Suffolk County Council (20041323)

**Response to the Action Points arising from
ISH5 and ISH6**

Bramford to Twinstead (EN020002)

17 January 2024

SHEET NO. 10

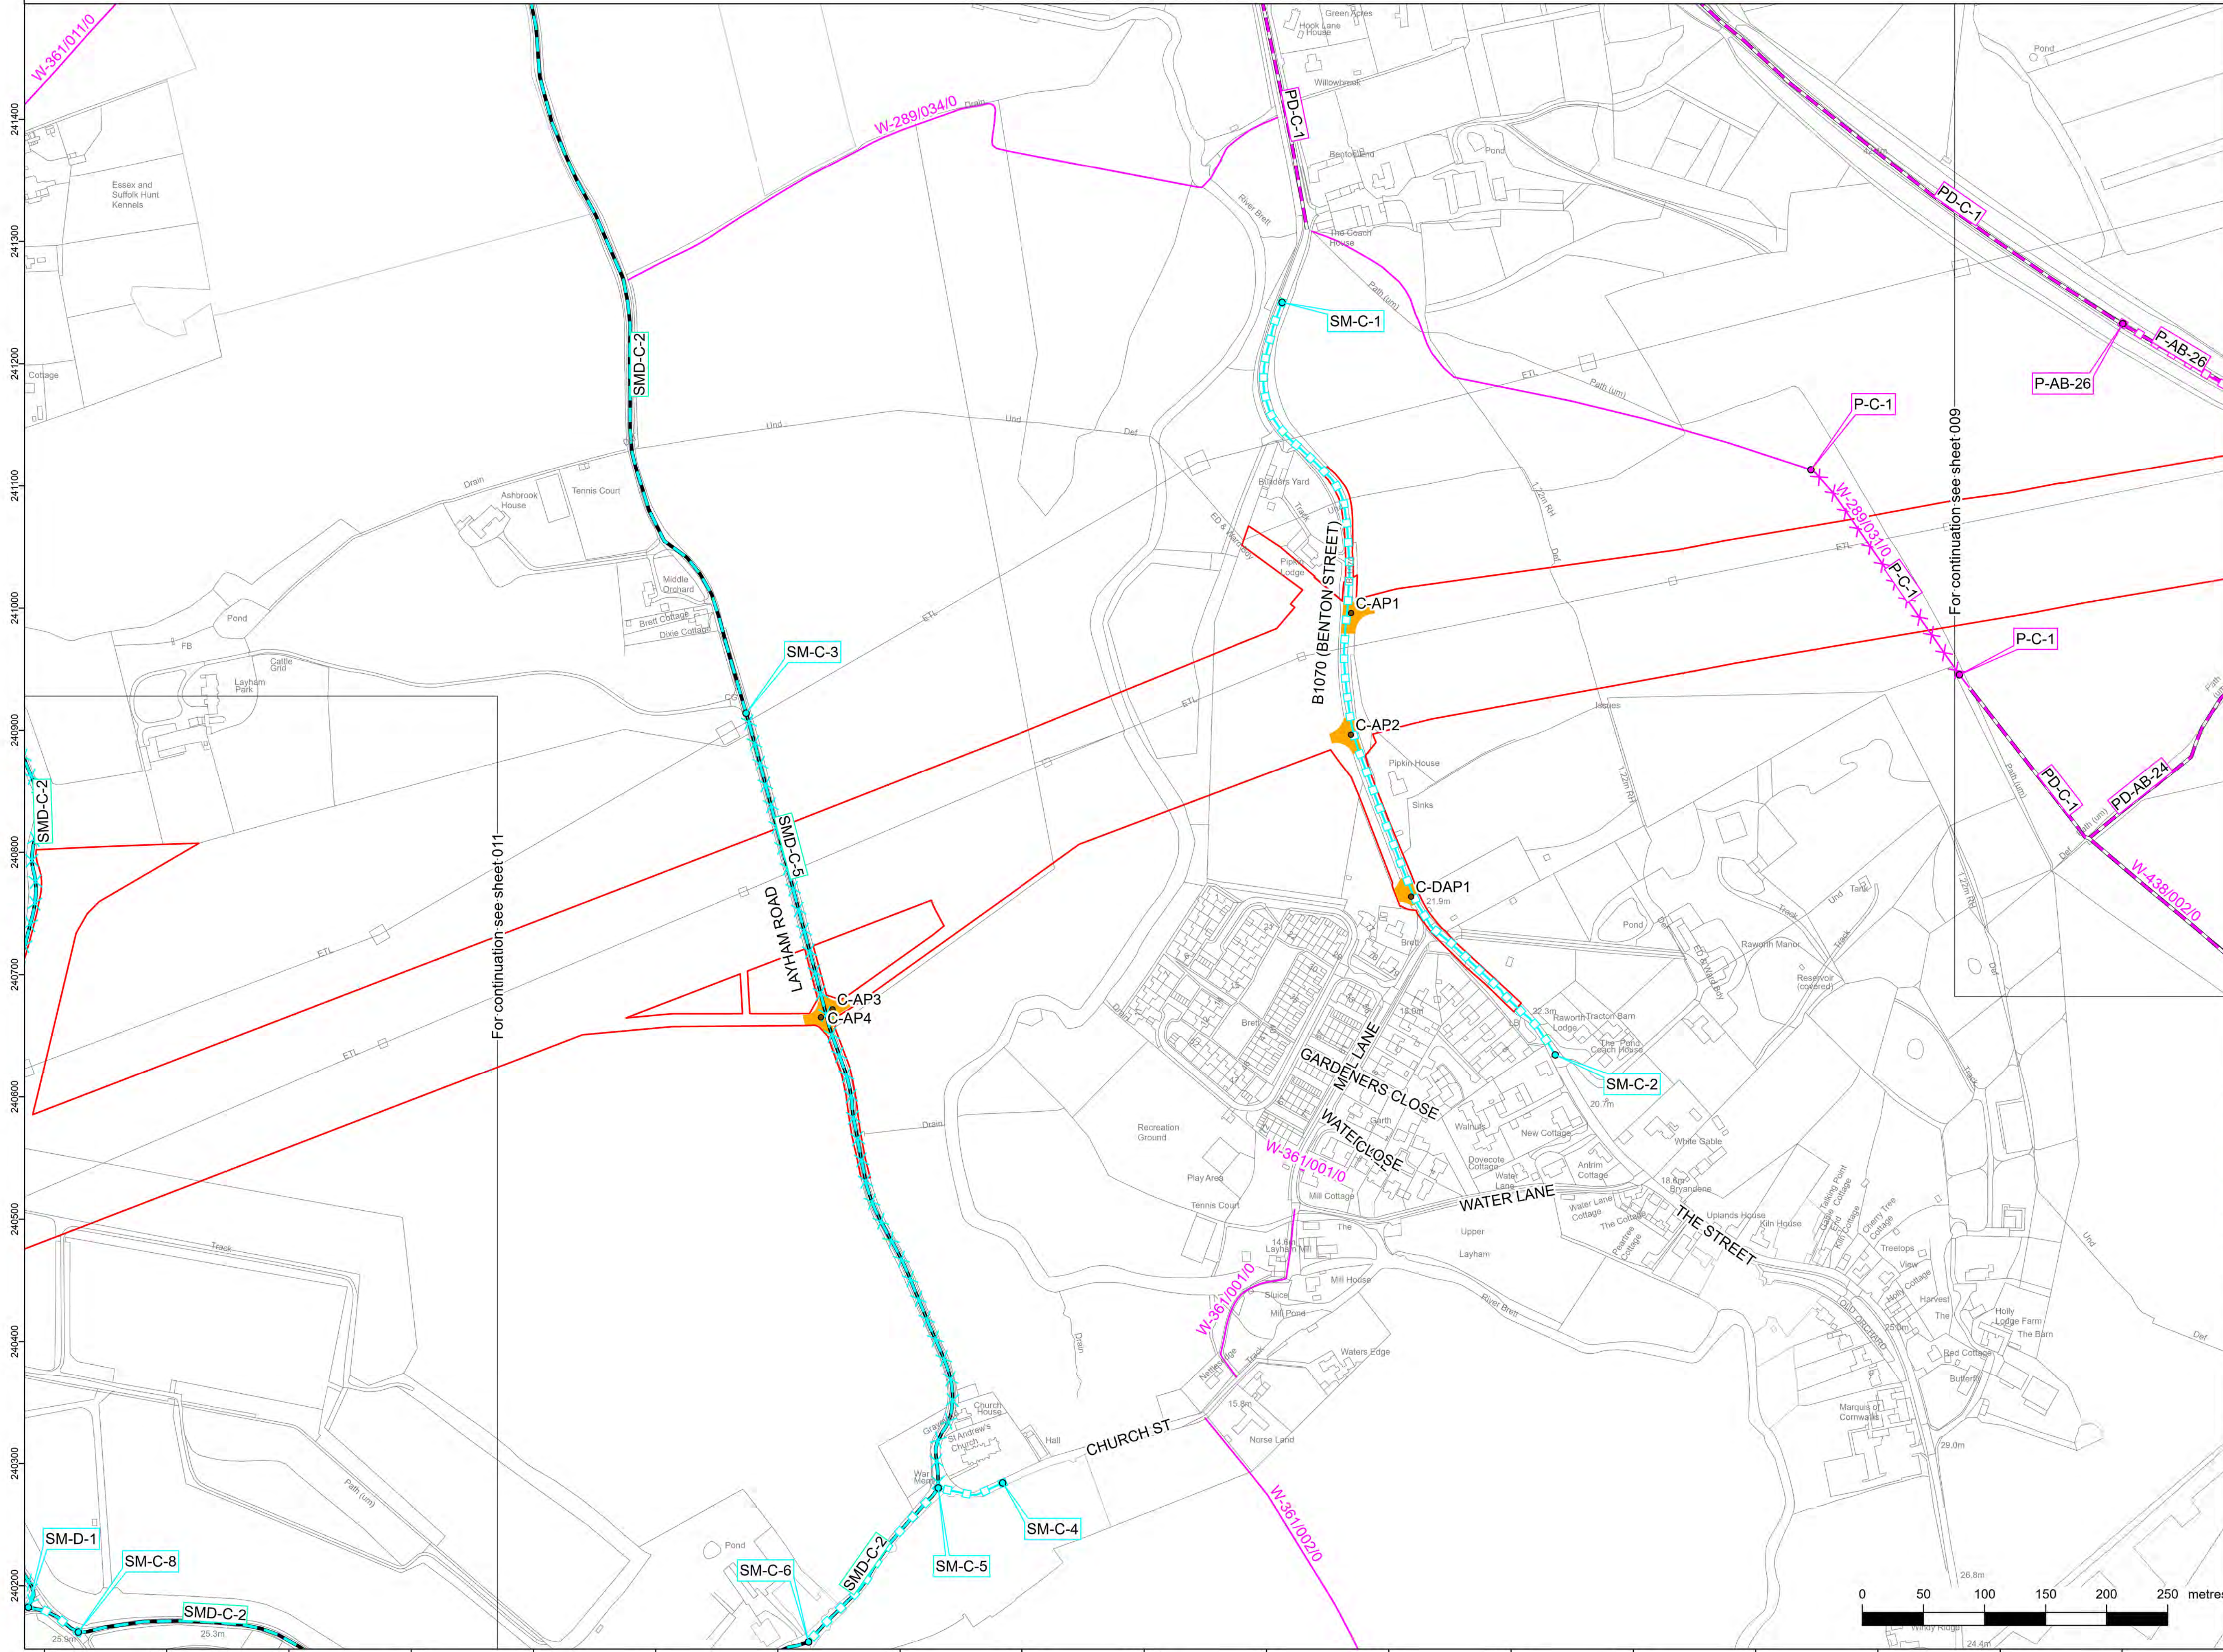
- 1.3. SM-C-1 B1070 (Benton Street) on sheet 10 appears to straddle Pipkin Hill and Benton End.
- 1.4. A134 on sheet 15 and 16 SMD-F-5 is Nayland Road and SMD-F-8 and SMD-F-3 Colchester Road to the north of this point.
- 1.5. SM-G-5 is on B1508 Bures Road sheet 20 and SMD-G-2 is on St Edmunds Hill, the boundary approximately 70m north of the southern cable run.

- 1.7. C-AP1 is on Pipkin Hill (not B1070 Benton Street).
- 1.8. Access points G-AP4, G-DAP1, G-DAP2 are on B1508 St Edmunds Hill.

- 1.9. C-AP1 is on Pipkin Hill (not B1070 Benton Street).
- 1.10. Access E-AP8, Access F-DAP1 are on Brick Kiln Hill (not Lane).
- 1.11. Access F-AP5, Access F-AP6, Access F-DAP2 are on A134 Nayland Road not Colchester Road (although F-AP5 and F-AP6 are close to the boundary between the two named roads).
- 1.12. Access G-AP3, Access G-AP4, Access G-DAP1, Access G-DAP2 are on B1508 St Edmunds Hill not Bures Road.

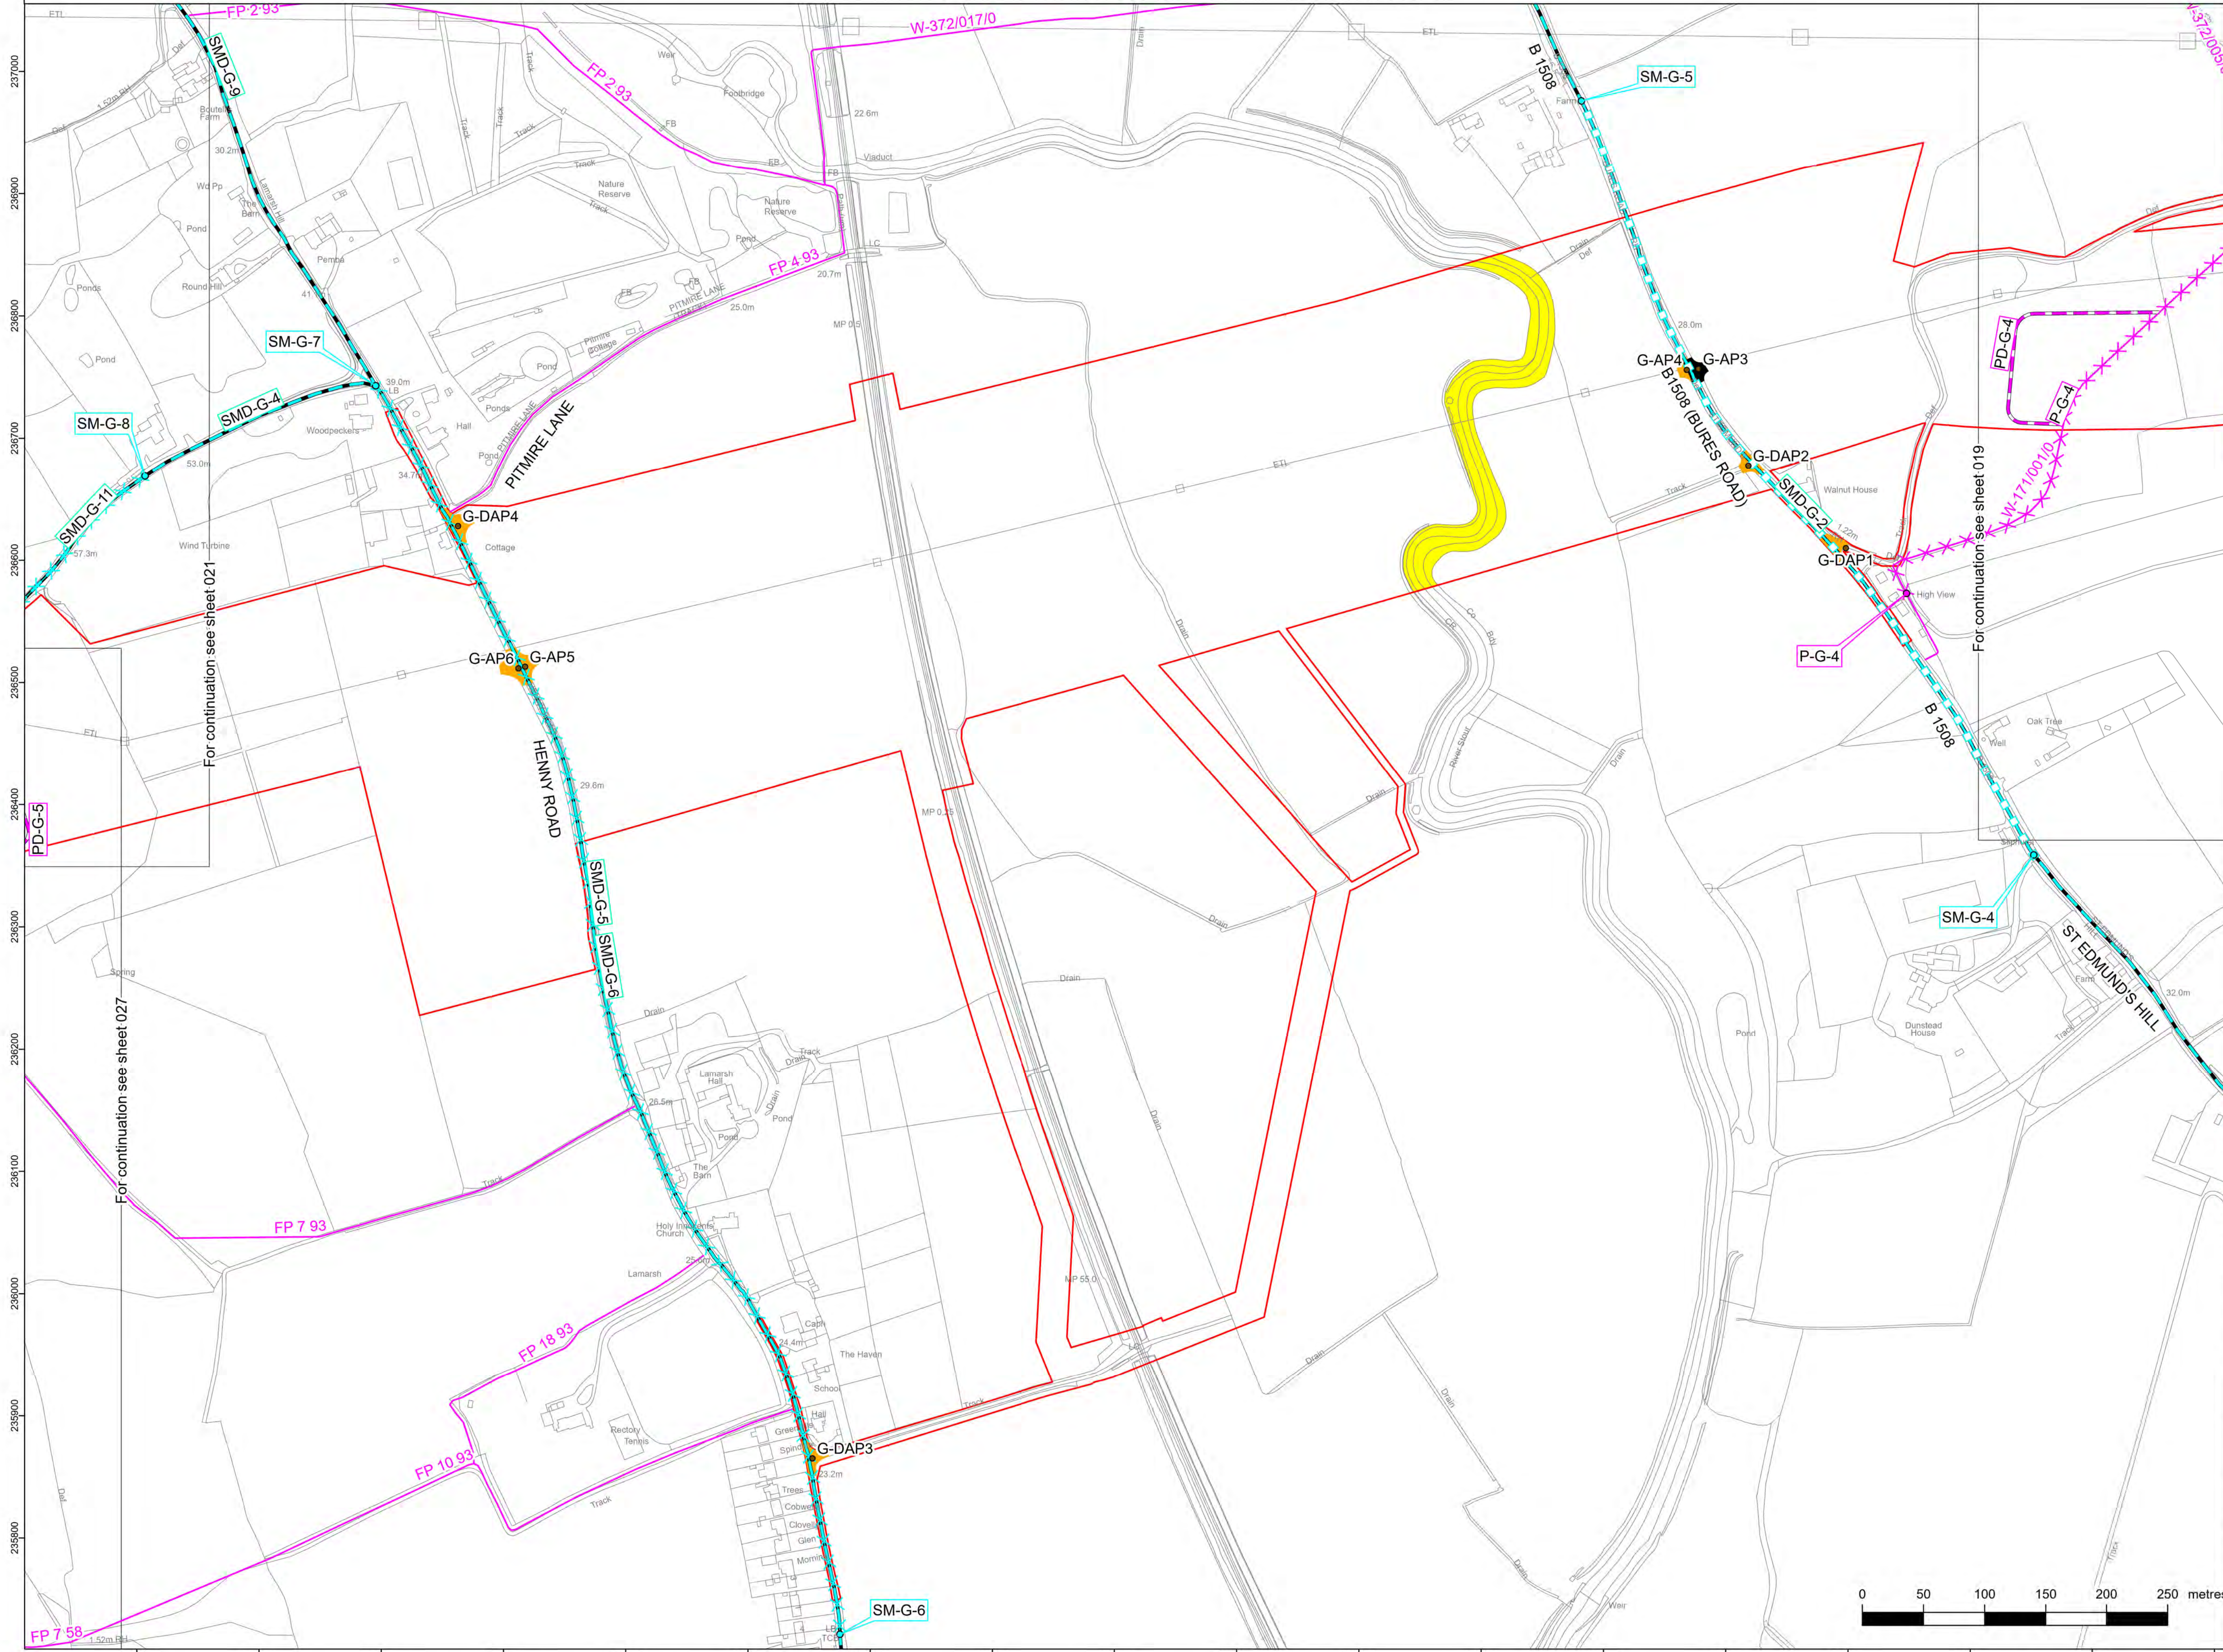
- 1.6. B1508 access G-AP3 being under the southern cable run is located within St Edmunds Hill rather than Bures Road.
